CITY OF ALBUQUERQUE

June 12, 2015

**RE: Unser & Vista Oriente Shell Building, Lot 1-B-3, Ladera Industrial Center,
Unser Boulevard
Grading and Drainage Plan
Engineer's Stamp Date 5-19-2015 (File: H10-D006A5)**

SHEET NO:
CG-101

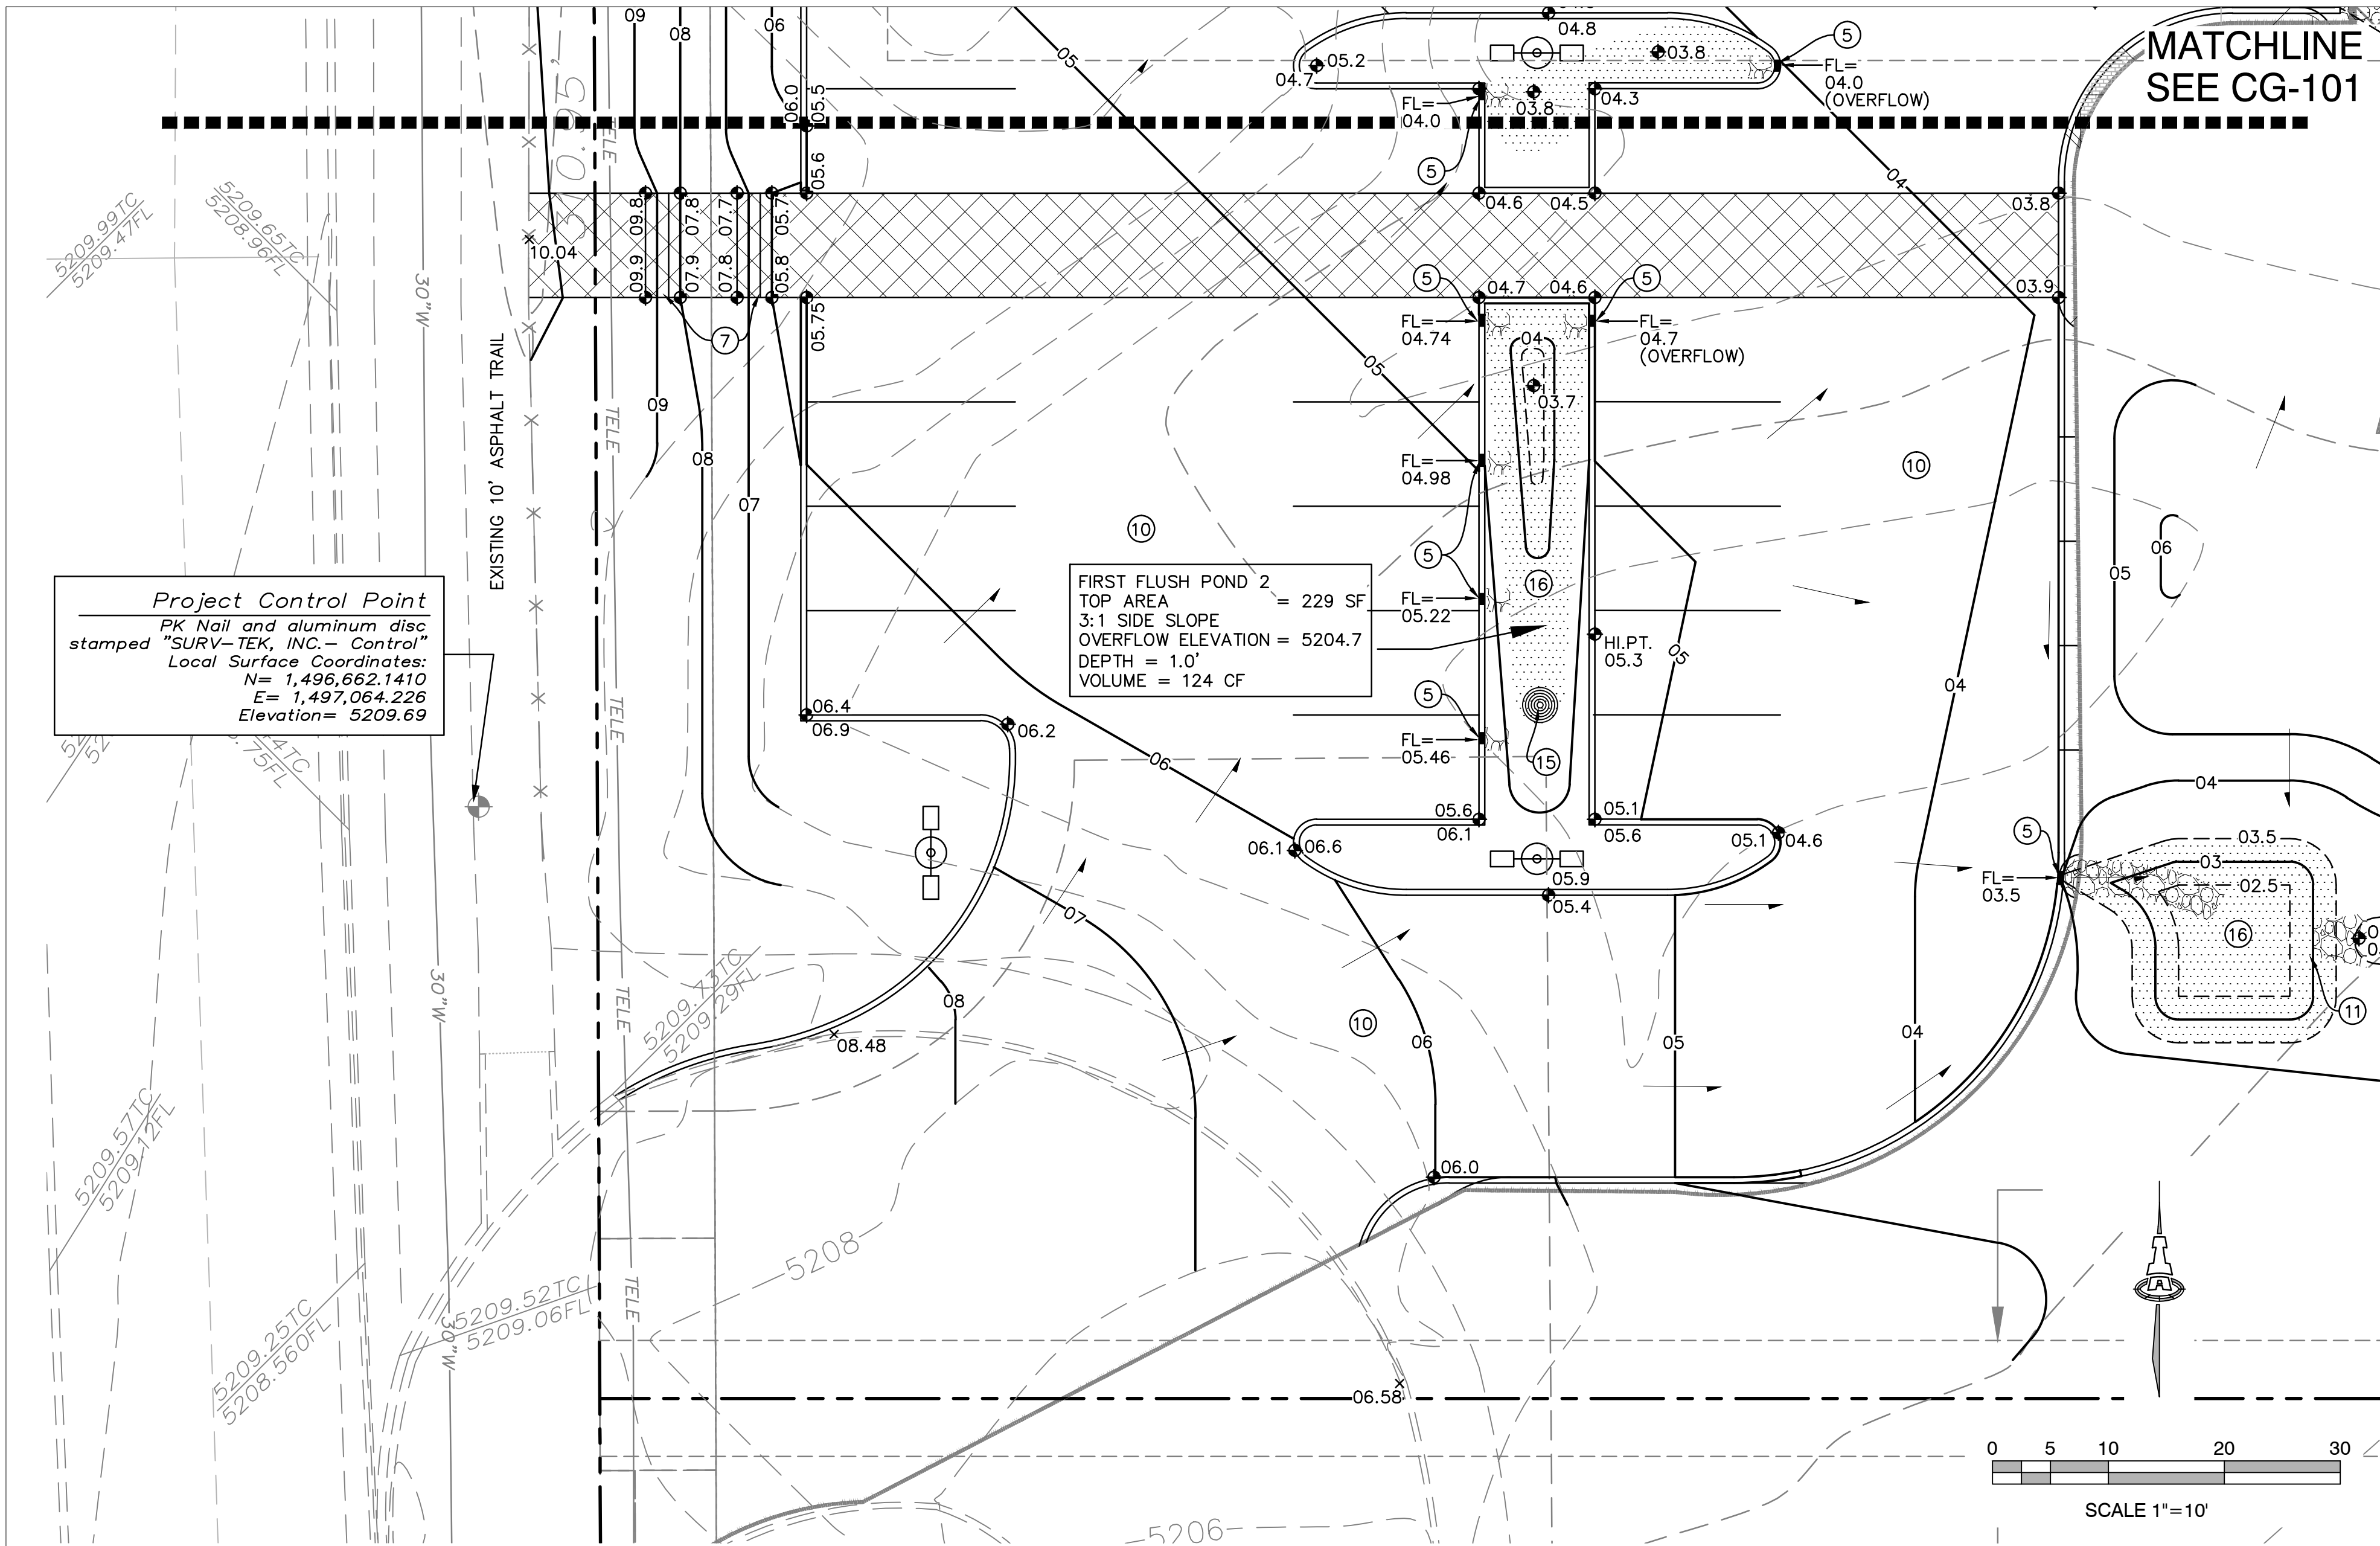
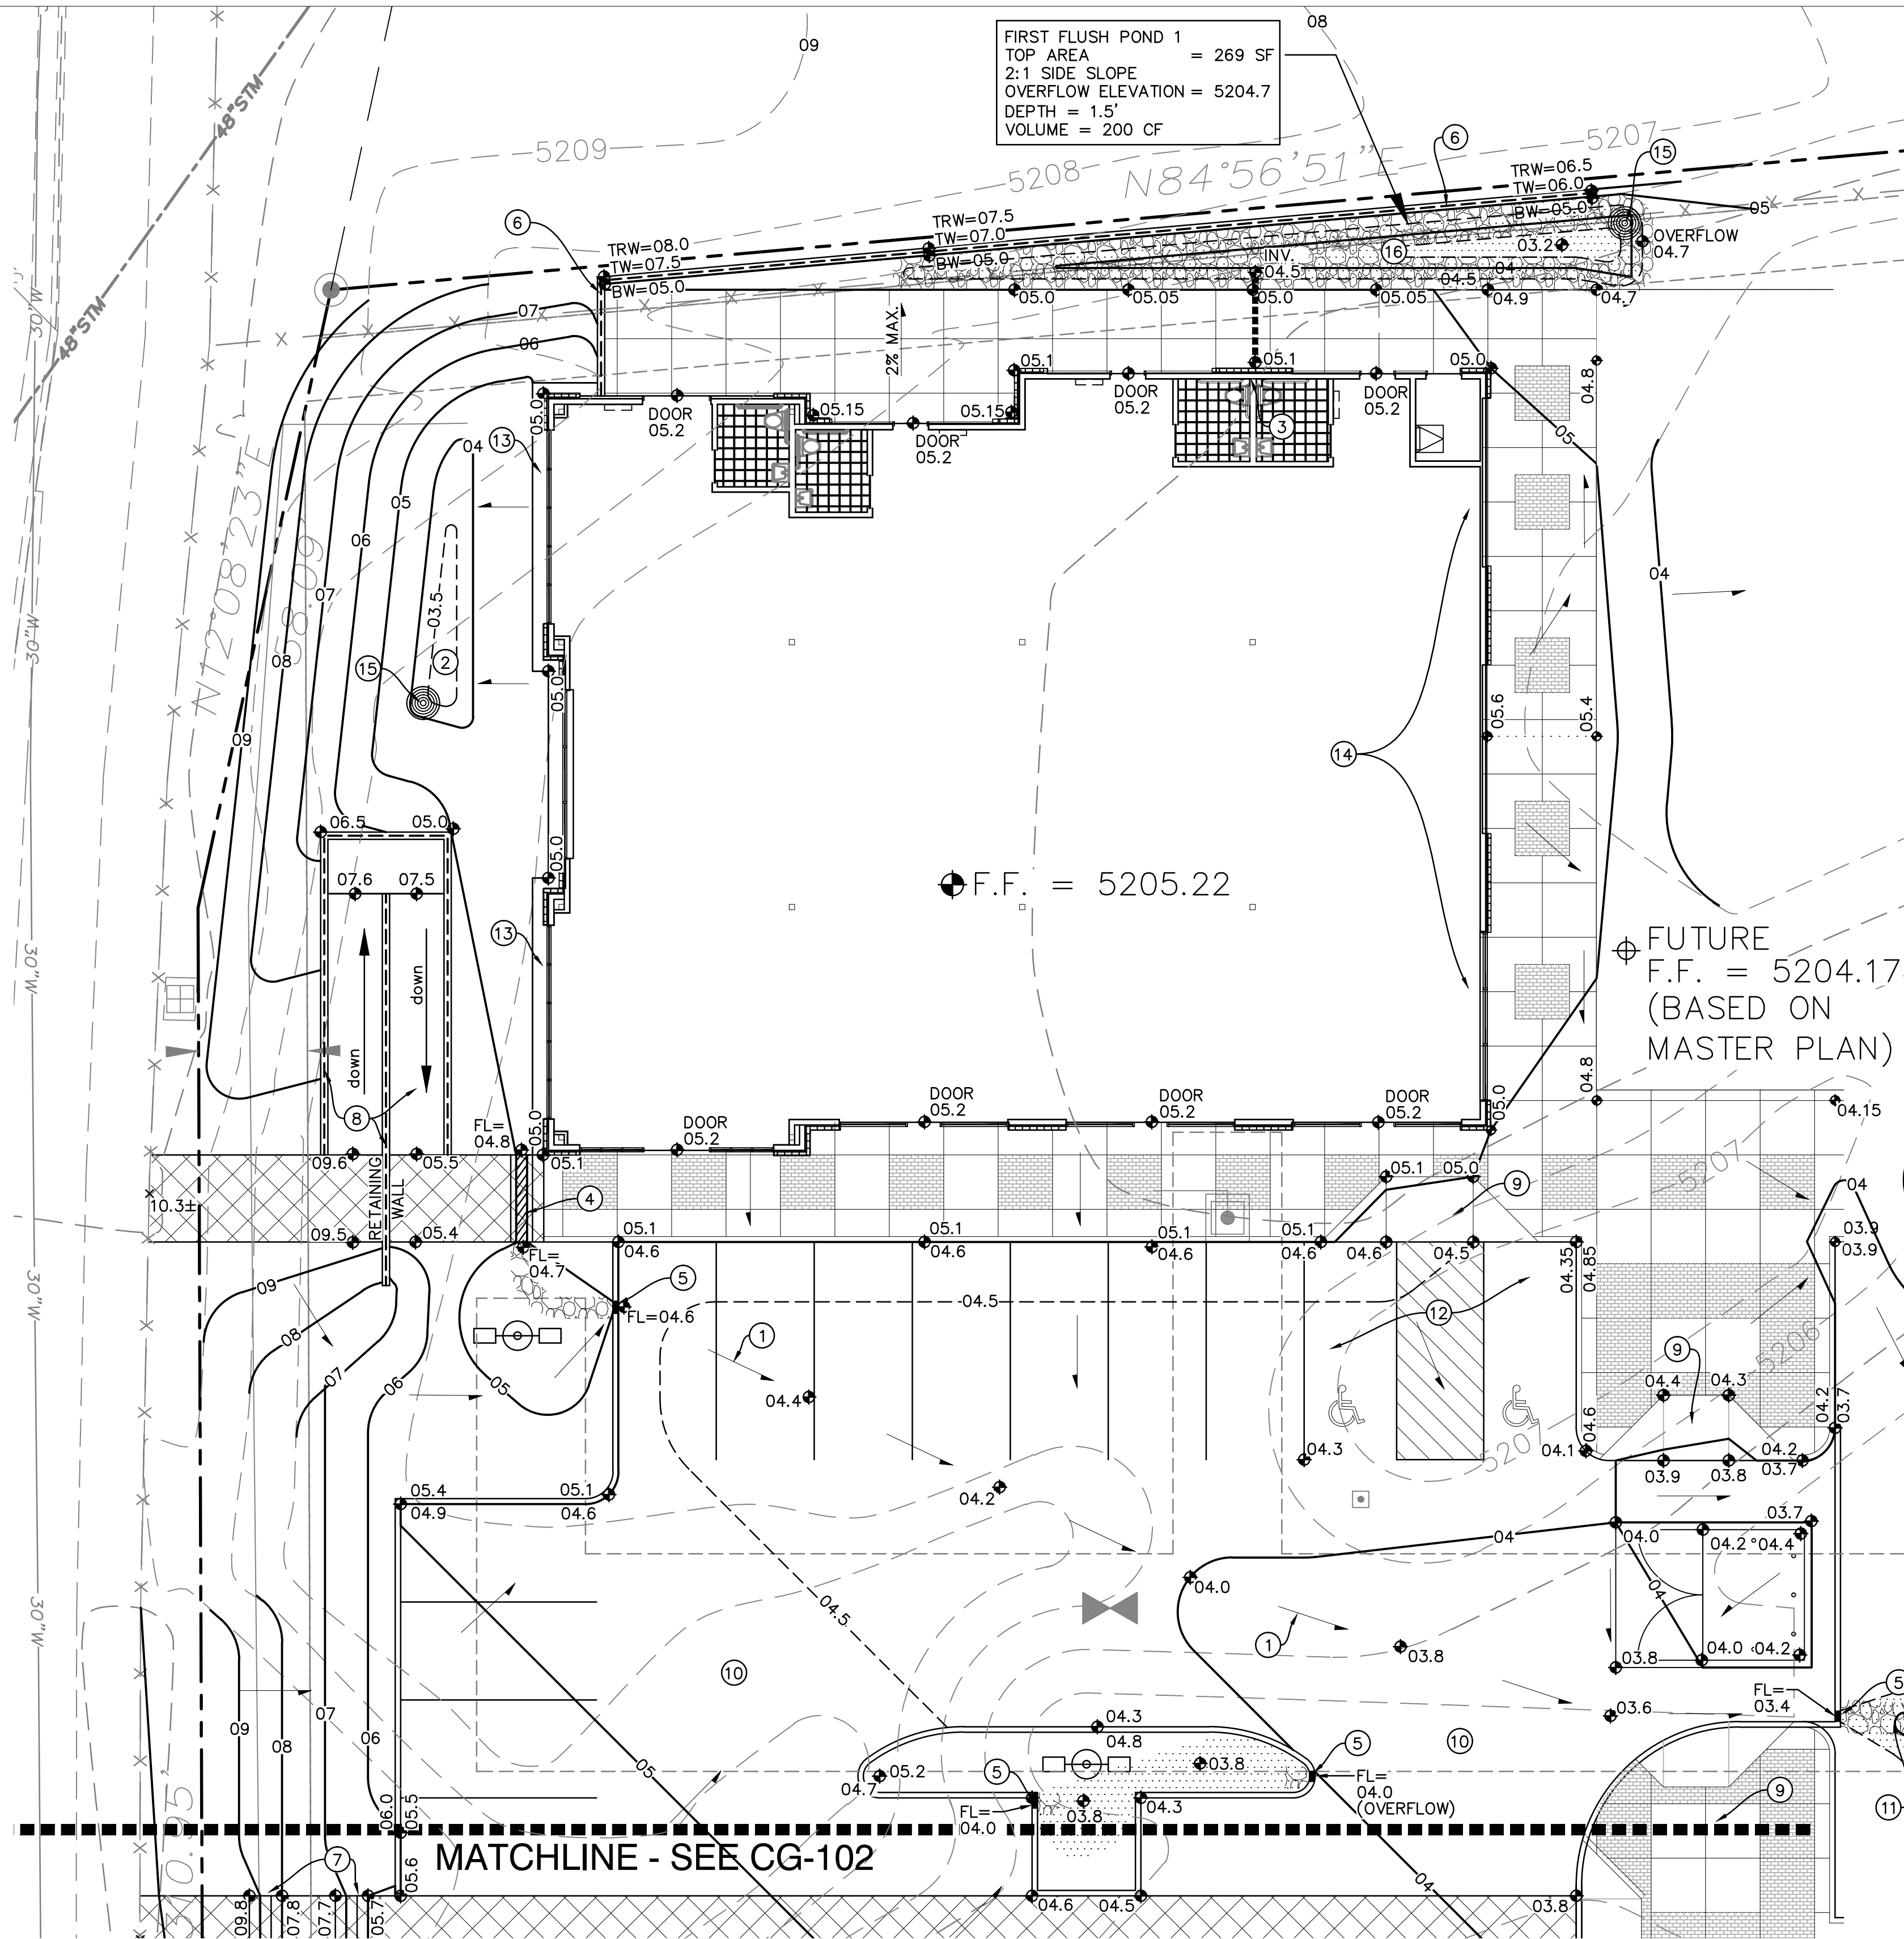
- 1) Provide excerpts from the Ladera Industrial Center Site Development Plan showing that the site adjacent to the east is accepting on-site flow. Since the storm flow is increased from existing conditions, a cross-lot access agreement may be needed unless one is already in place to accept the proposed 100-year flow.
- 2) A couple of the new spot elevations were cut off on the right side of the plan view on Sheet CG-102.
- 3) For Basin 3 on Sheet CG-501, the labeling of the basin area on the plan view needs to match the basin area in the calculations. Also, label lot line for Lot 1-B-3.
- 4) Show roof drains.
